TOWN AND COUNTRY PLANNING ACT 1990 NON MATERIAL AMENDMENT

Reference: H08-1031-25 **Date of Decision:** 31st October 2025
Applicant: R K Wilson Builders Ltd.
C/O Robert Doughty Consultancy Limited
32 High Street
Helpringham
Sleaford
NG34 0RA
Location: Riseholme Farm Windmill Lane Gosberton Risegate Spalding
Description: Erection of 6 single storey dwellings and garages, formation of parking and bin collection point and reinstatement of existing access - approved under H08-0282-24. Amendments to foundation design to that required under Condition 3 of approval H08-0282-24

South Holland District Council hereby give notice that this application has been REFUSED in respect of the non-material amendments referred to above for the following reason(s):

PROPOSED STRIP FOUNDATION ARRANGEMENT –
GARAGE OF PLOT 4 & 5
SCALE 1:50

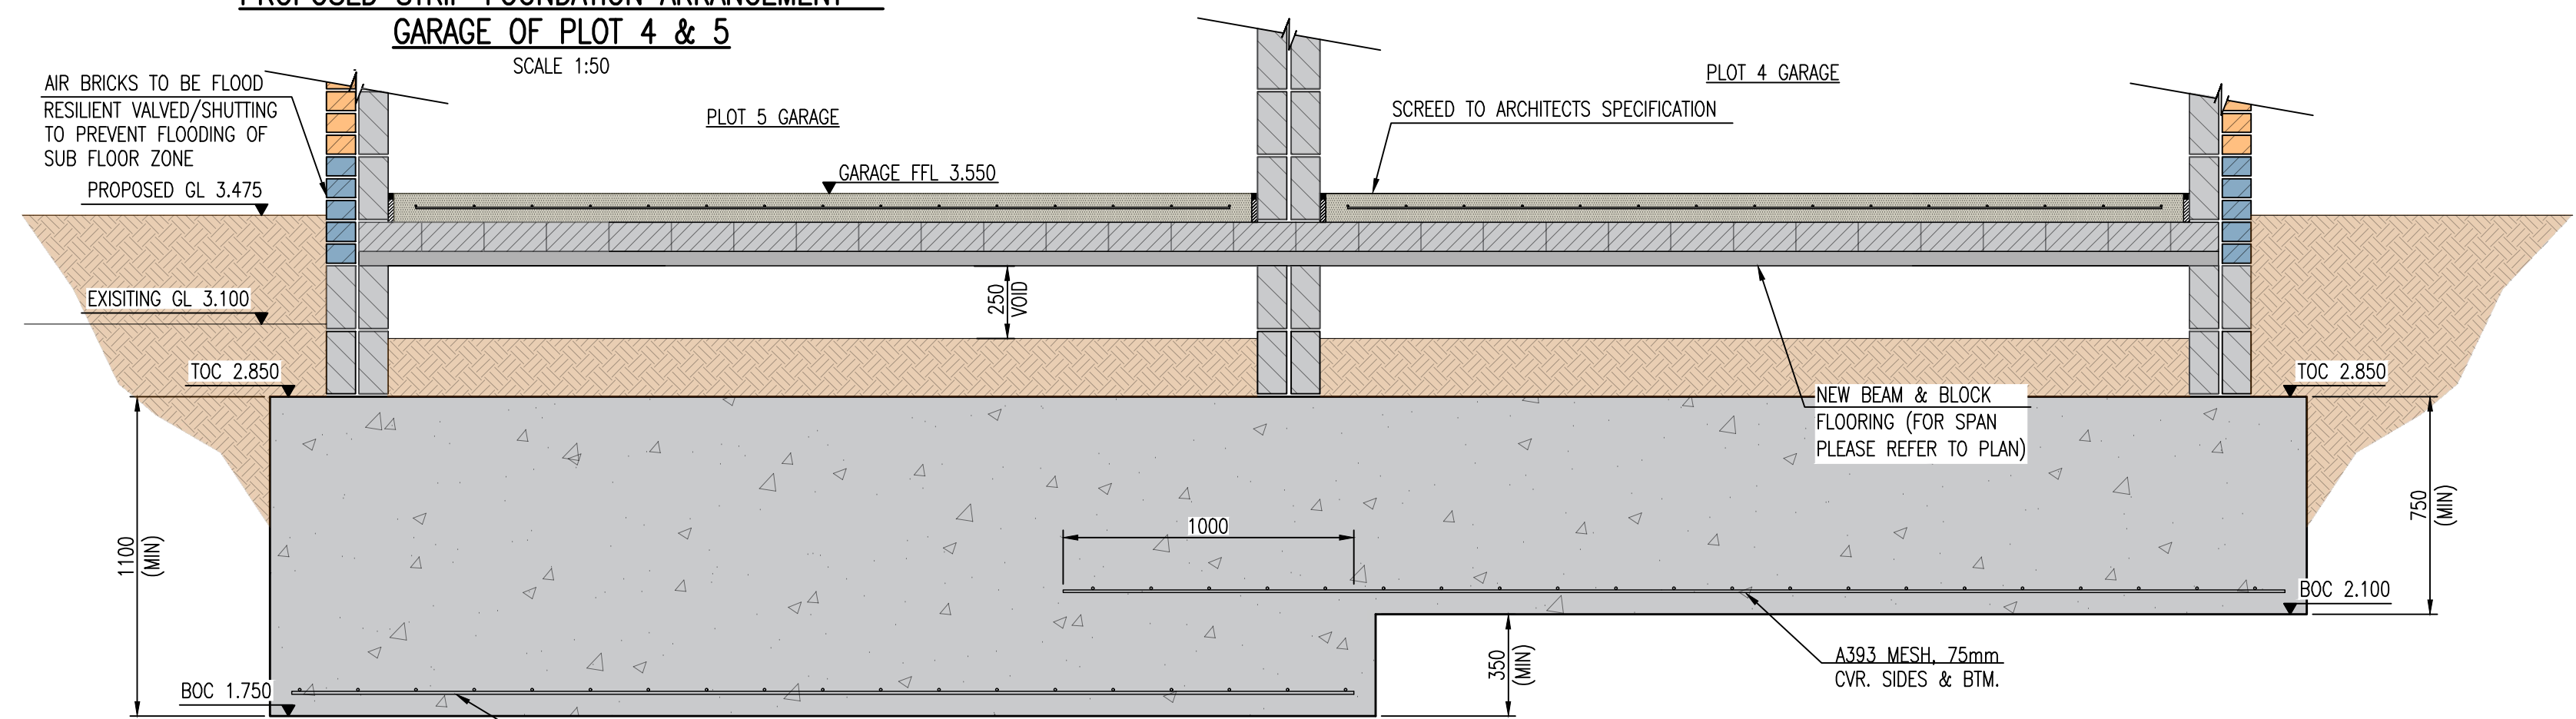
- 1 Point 8 of South Holland District Council's guidance on non-material amendments confirms that such amendments must not result in a fundamental change to the design of the approved building. The approved Flood Risk Assessment (FRA) by RM Associates establishes a critical flood resilience requirement that "the ground floor shall be constructed with a solid concrete floor with no voids beneath and no low-level wall vents." The proposed introduction of a strip foundation incorporating voids beneath the floor would fundamentally alter this key element of the approved design and directly conflict with the flood mitigation measures integral to the scheme's acceptability.

Accordingly, the amendment would constitute a material change to the approved development and cannot be treated as a non-material amendment under Section 96A of the Town and Country Planning Act 1990 (as amended).
